Thank you for your review and comment provided to the UDON traffic study. Please see individual responses throughout this document.

Re: UDON Rezone Traffic Study
El Paso County, Colorado

PCD File # CS243

FIGURE 3
 UDON REZONE
 EL PASO COUNTY, COLORADO
 NON PASS-BY PROJECT TRIP
 DISTRIBUTION – SOUTH AREA

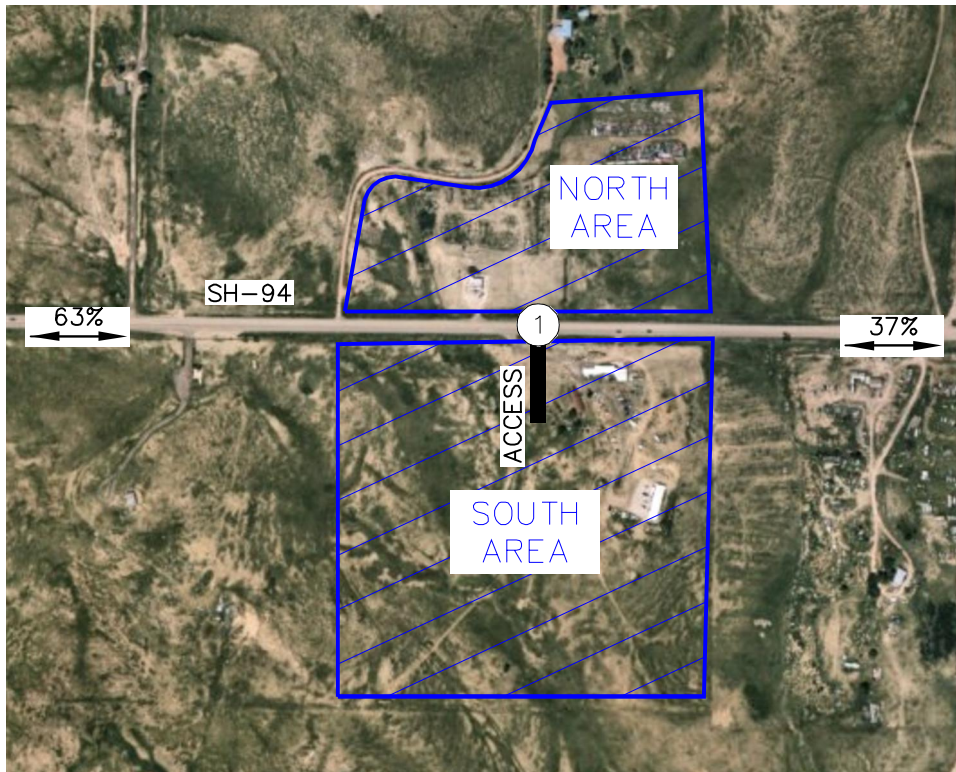
Please verify the the location of HWY94 on all trip distribution maps. HWY94 should be between the north and south development areas but all the maps show HWY94 at the bottom. Same comment for pages 22-31. Please label HWY94 and add north arrow as needed on all pages

The annotation bubbles are not identifying where the roadway is located but simply labeling intersection and/or access names. The north legend arrow was previously located on the top left of each figure.

UDON SOUTH - CONCEPT SITE LAYOUT

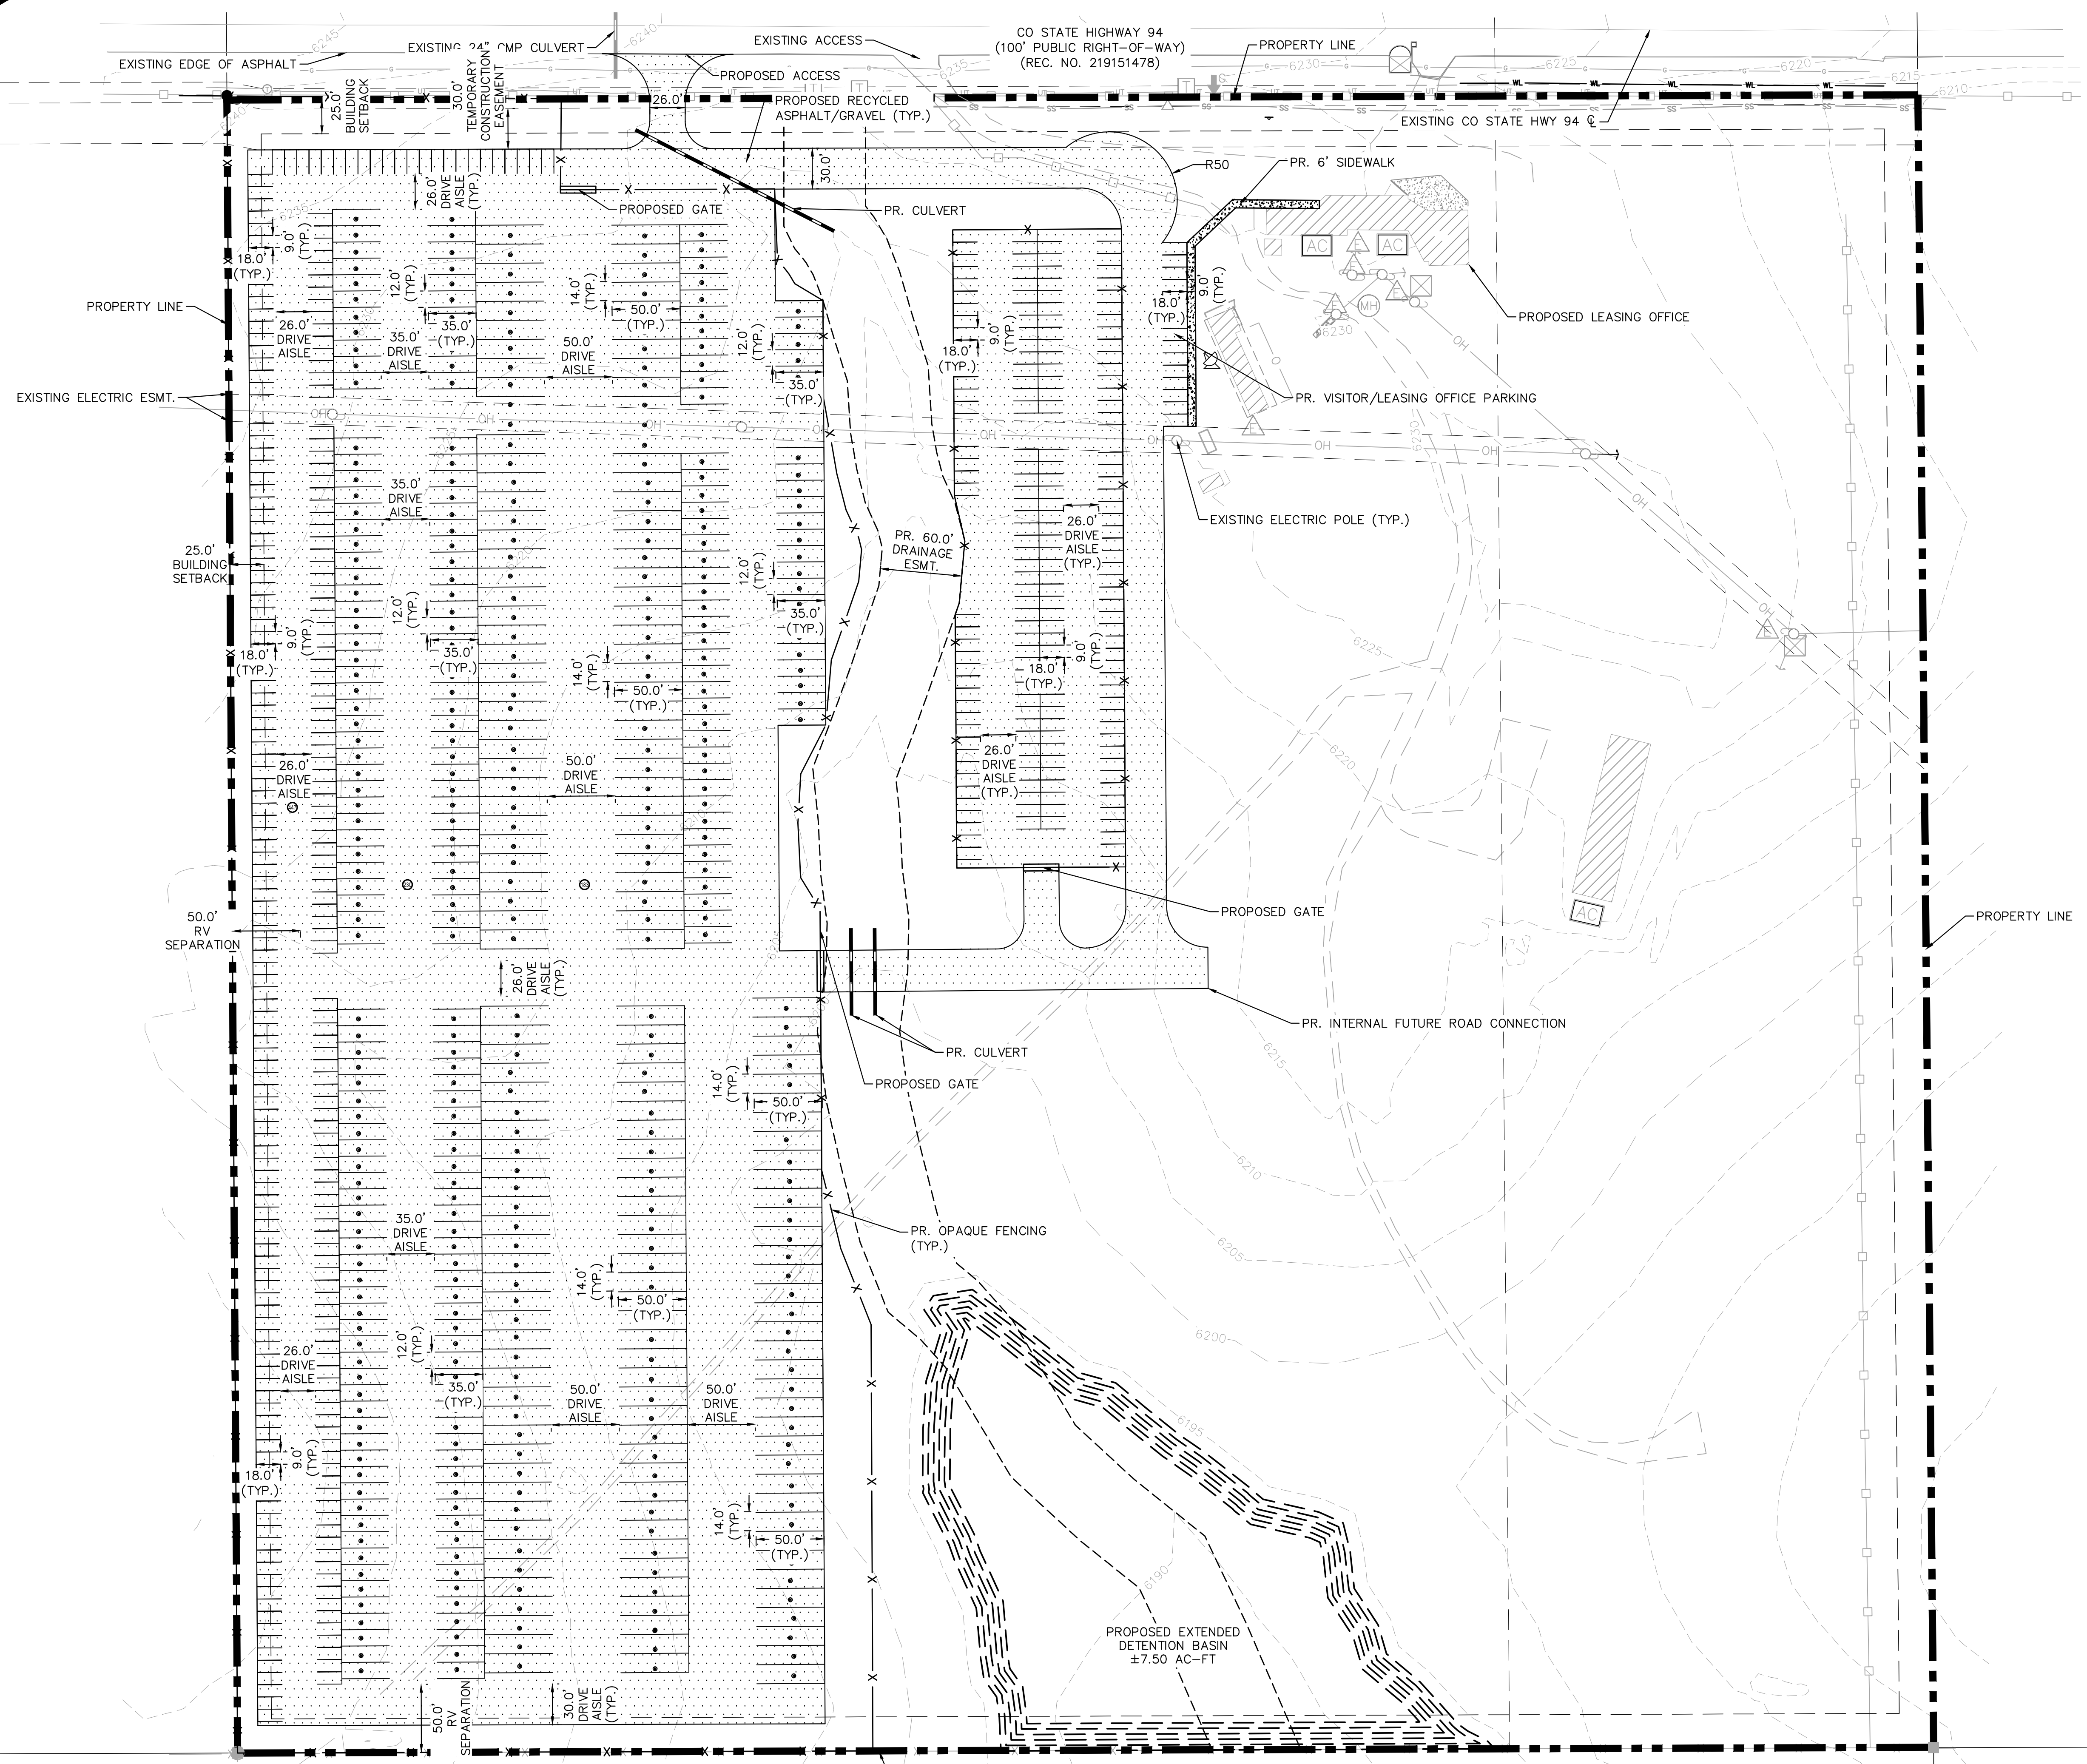
Min 35ft wide access from an arterial road per County ECM. Comply with CDOT requirements.

Does not match Letter of intent or the SDP

The driveway will provide a minimum width of 35 feet.

An updated site plan and parking data has been provided in the updated submittal
